From: PaghamBeach [REDACTED]
Sent: 08 January 2021 15:37
To: Amber Willard <Amber.Willard@arun.gov.uk>
Cc: Nicola Swann [REDACTED]
Subject: Application ref: P/121/20/HH - 31 West Front Road, Pagham

This Application Site has a history of Refusals of Applications seeking to erect garages within the confined nature of the site as a result of the over-sized bungalow. The District Council's records will show that previous Application P/13/08 to erect a new garage on the site was Refused on grounds of overdevelopment of the site, and subsequent Application P/142/08 and amended Application following the Refusal of P/13/08 was also Refused on the same grounds and subsequently Dismissed on Appeal in 2009.

120 ELEVATIONS - AS PROPOSED
Scale: 1:50

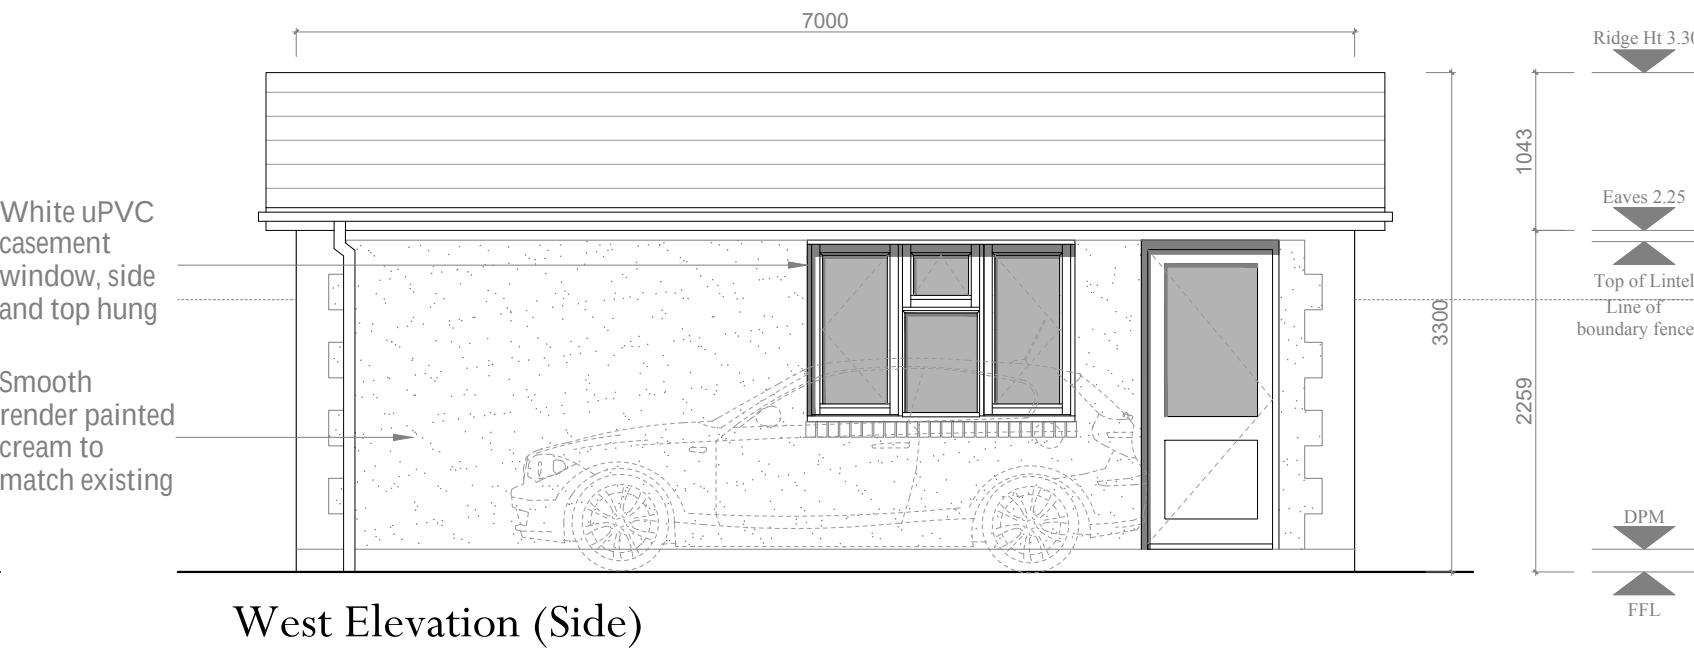
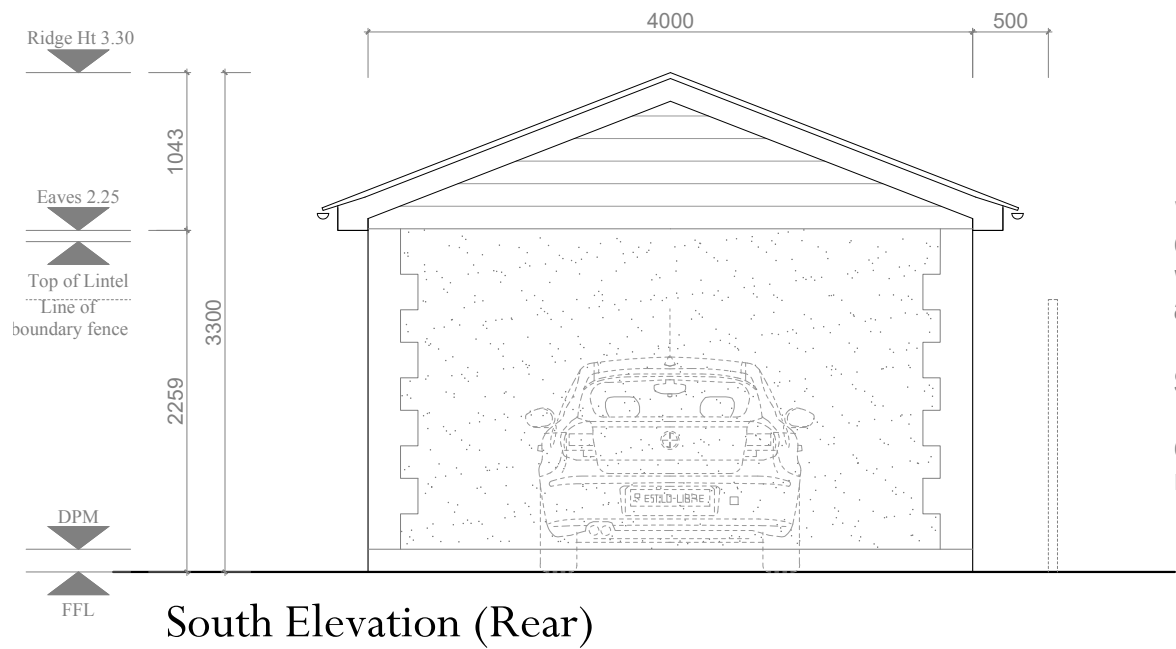
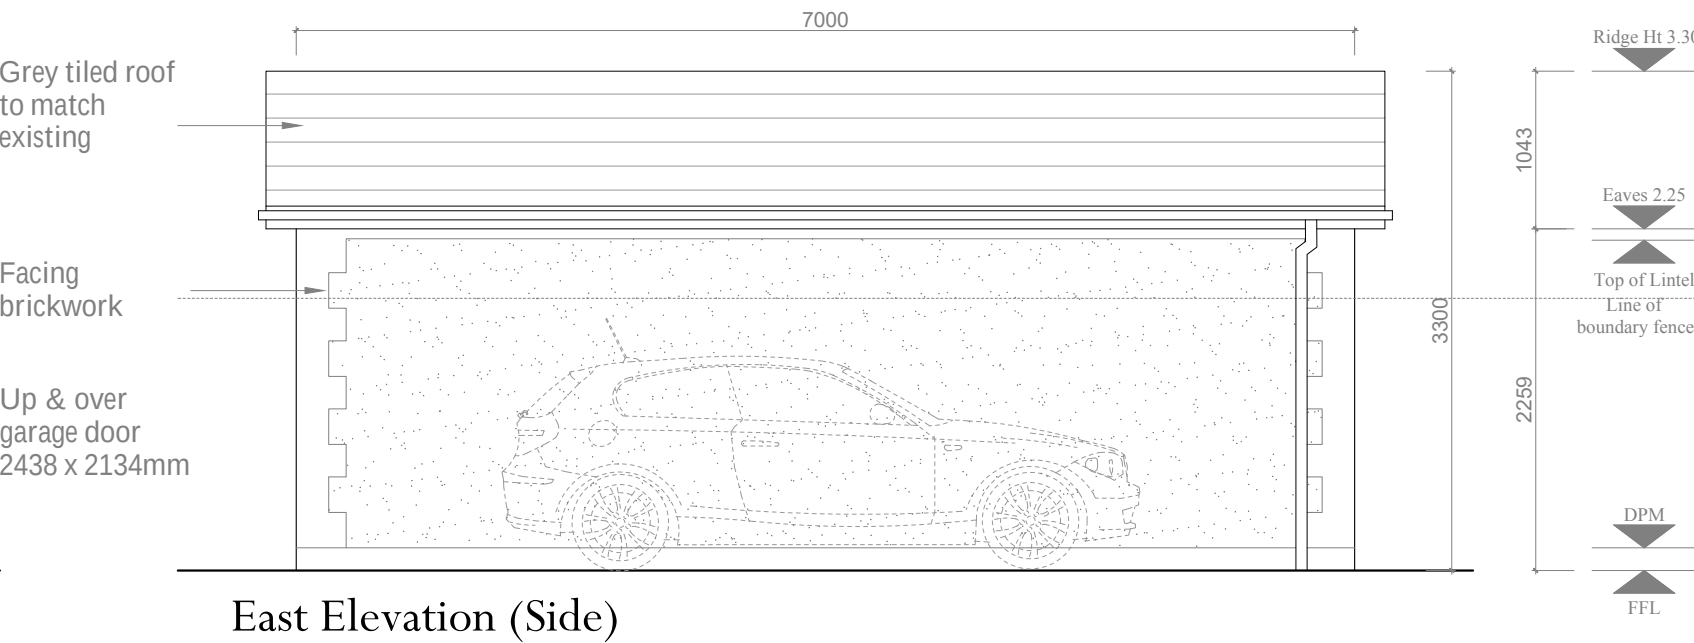
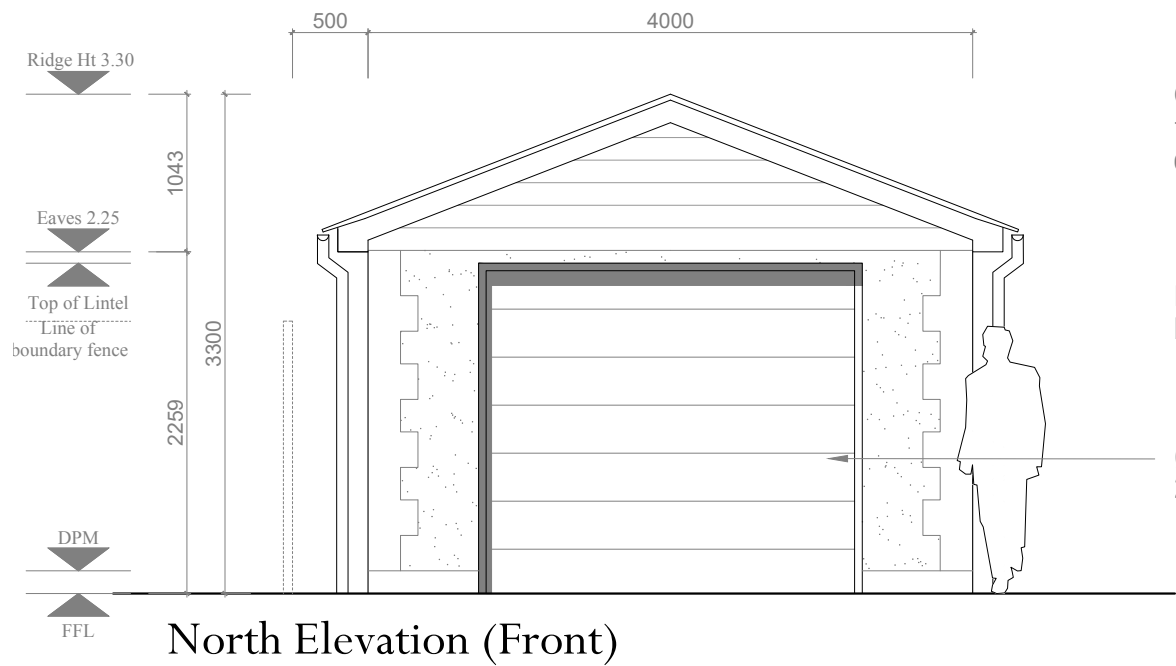
As a result of the footprint of the existing bungalow there is restricted space to be able to accommodate vehicles manoeuvring into a garage on this forecourt. The width of the Company's private road of West Front Road in this location has been reduced to less than 6m, and with the proposed new garage to be sited with its front elevation exactly on the front boundary of the Application Site it will not be possible to manoeuvre a car into this garage. The new garage will also impede parking of vehicles and boats on trailers on the remainder of the forecourt. The site is already over-developed and further buildings will seriously overcrowd this site, to the detriment of both the site and its neighbours.

The existing concrete paved forecourt is impermeable and apparently without provision for surface water drainage, which is bad practice and results in run-off onto the private road, which is unacceptable.
